Submission No.			118		
Organisation Name or Name of Submitter			HSE National Drug Treatment Centre - Austin Lyons A/Chief Assistant Technical Services Officer HSE Capital and Estates

Item No.	Section Ref.	Page No.	Observation Statement	TII Response	
Letter Re: Railway (Metrolink-Estuary to Charlemont via Dublin Airport) Order 2022					
1	Letter	2	TII also note in this correspondence that HSE may be an owner, or occupier of the land, or have rights over or an interest in the land, referred in the documents which will accompany the Railway Order application. 30/31 Pearse St. is a HSE property that accommodates the National Drug Treatment Centre (NDTC) and the NDTC Laboratory. Whilst the HSE are supportive of vital infrastructure such as MetroLink we also remain concerned about the potential risks and impacts on our site and service delivery at this location, both during the construction phase and post completion of the Metrolink project. To this end, we attach with this submission a Technical Note from OCSC (dated 21st Nov'22) summarising their findings within the short time frame available for review and outlining the concerns of the HSE regarding the potential impacts on the build

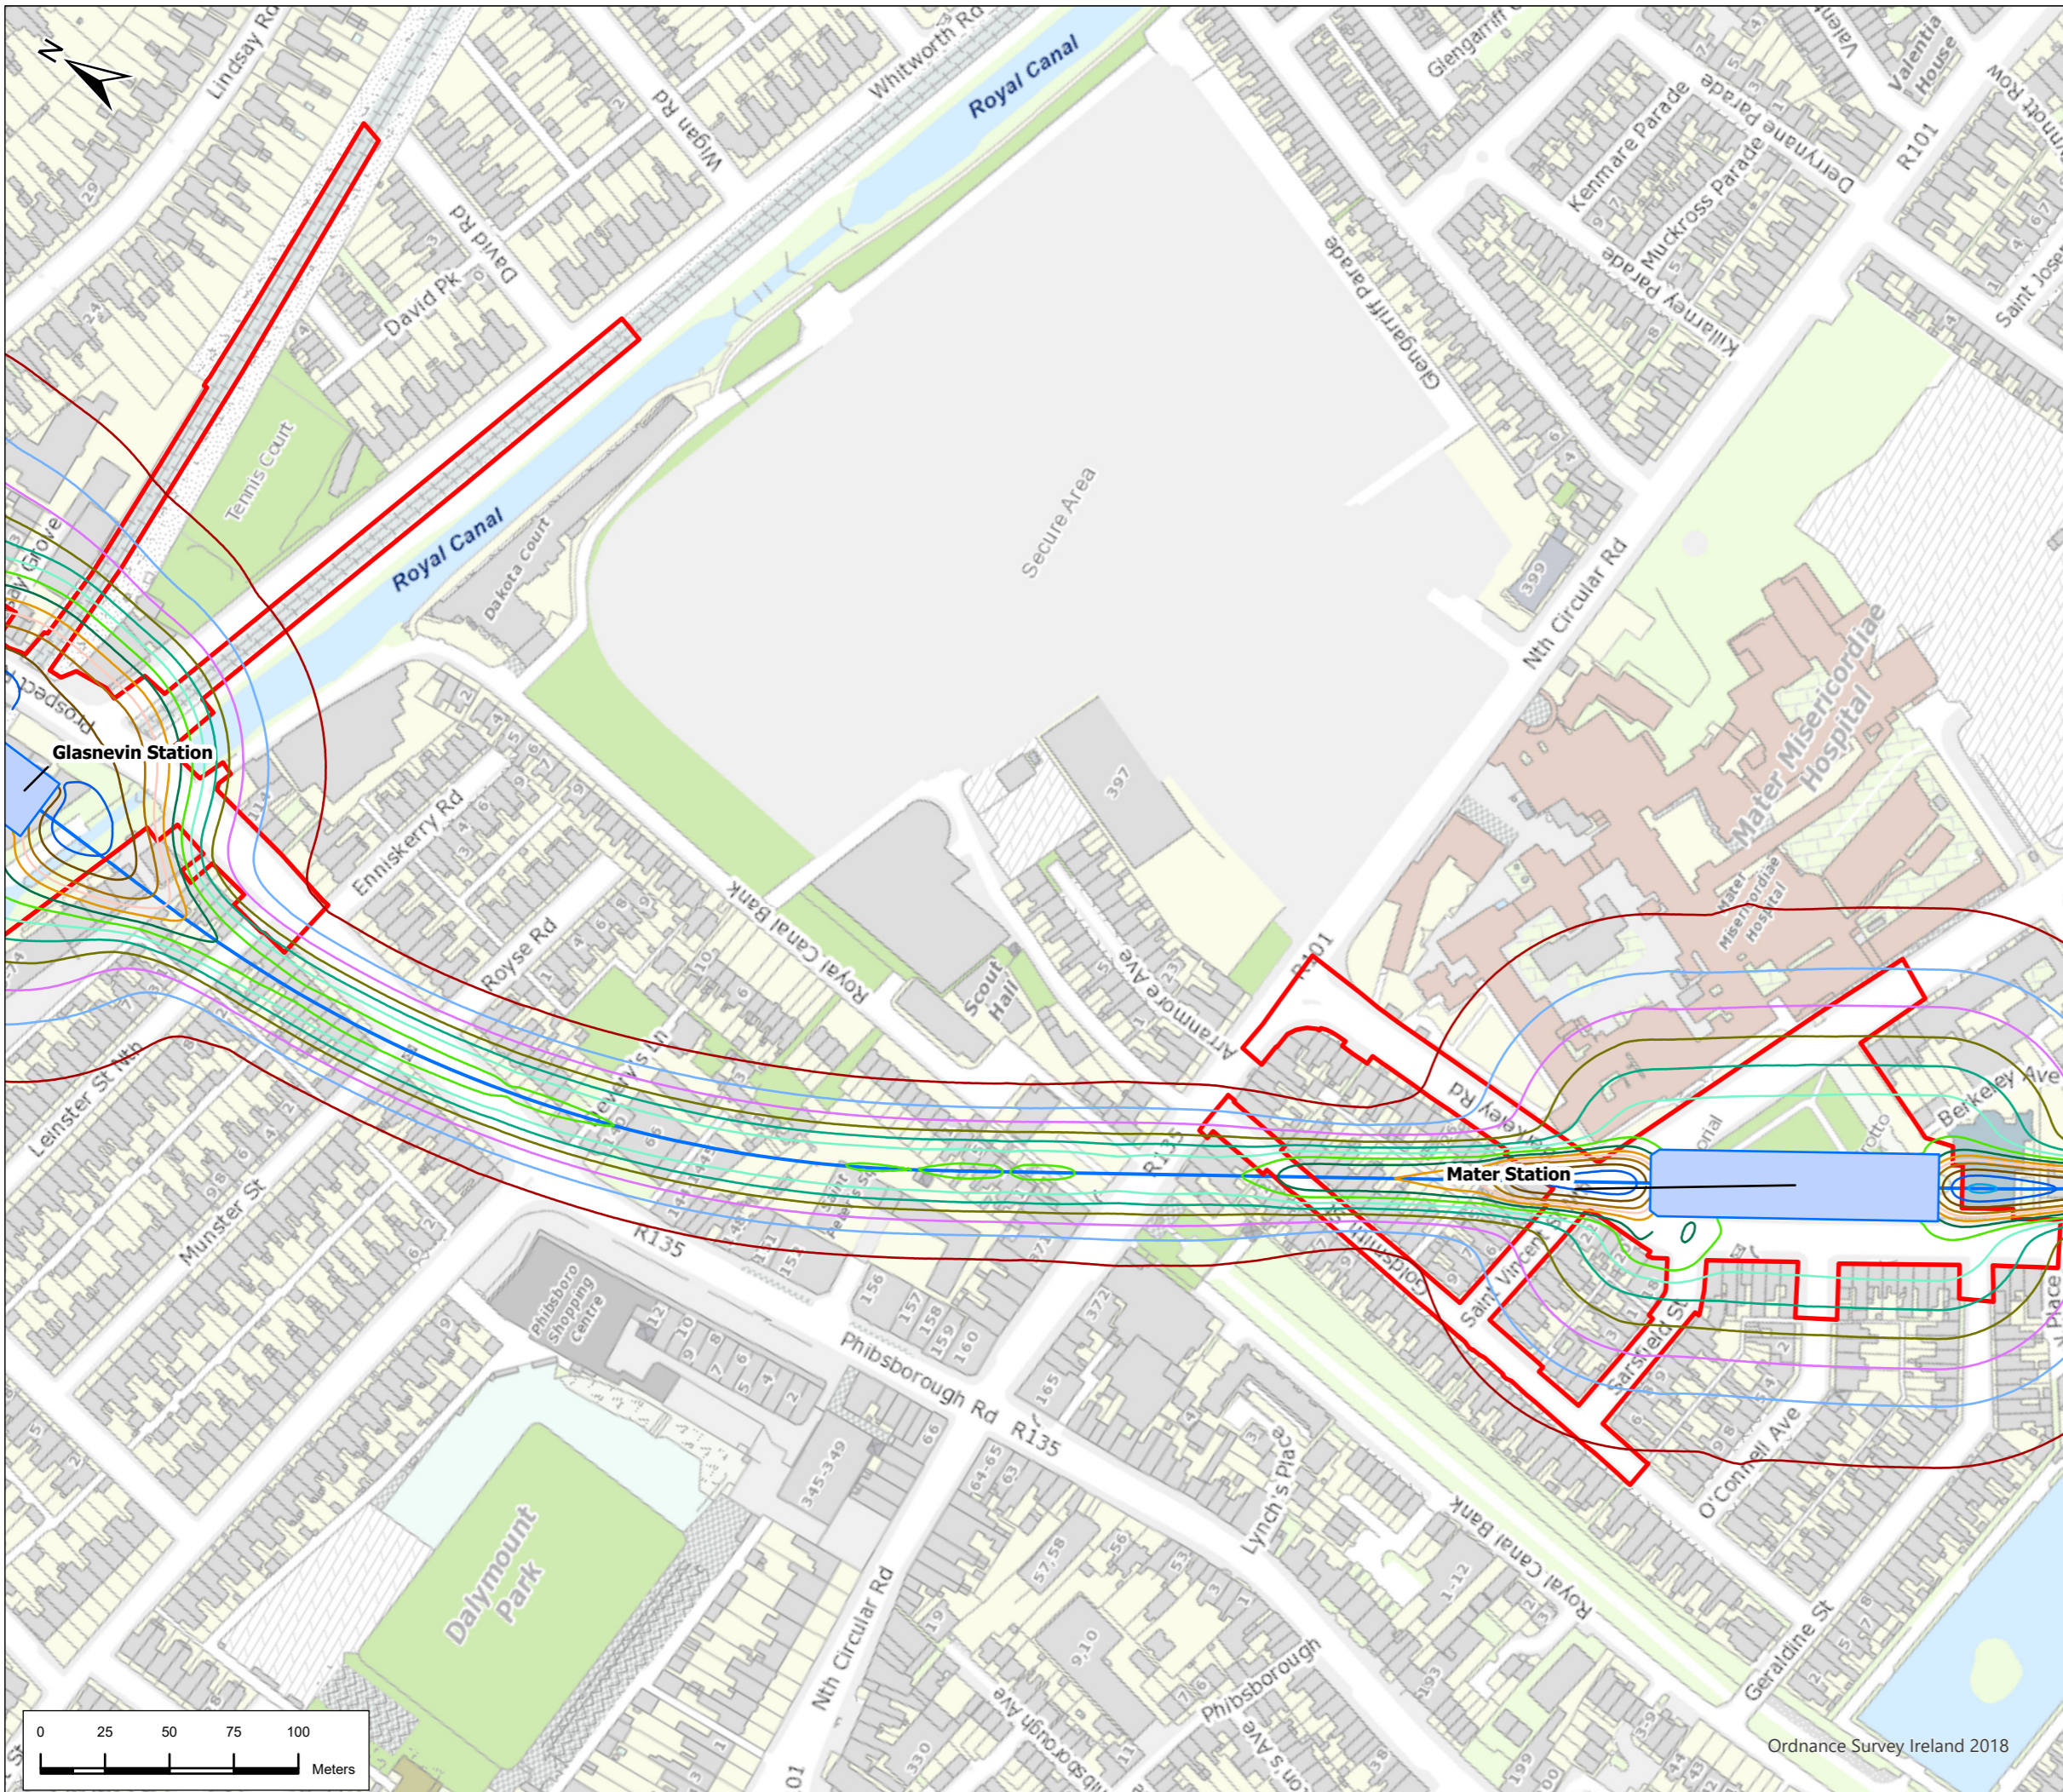
10	Technical note Section 5- Potential Impacts Section 5.2.1 Settlement	12	A marked-up extract (extract Fig 20.16 below) of the Phase 1 assessed "Greenfield" settlement contours relating to 30/31 Pearse St. is set-out below and from this assessment, it can be seen that the MetroLink has the potential to generate settlements of between 1mm to 20mm(plus) across the building footprint. More particularly, the assessment predicts a potential differential settlement varying between the 10mm-20mm contours across the area of the new lift shaft thus rendering vulnerable to out-of-plumbness. Such differential settlements have the potential to cause damage across the building and will thus necessitate the more detailed Phase 3 building damage impact assessment (map in PDF)	<p>The assessment details are given in the Chapter 4 of the Damage Assessment Report of Buildings and Other Assets.</p> <p>The settlement contours shown on Figure 20.16 of Appendix B are based on Phase-1 assessment with very conservative (absolute worst case) tunnelling volume loss parameters and its purpose is to define the boundaries for the buildings for subsequent assessments. However, Phase 2a has been carried with refined (but still conservative) tunnelling volume loss parameters with the consequent reduction in the greenfield settlements. This assessment identified that negligible impacts are predicted for this building.</p>
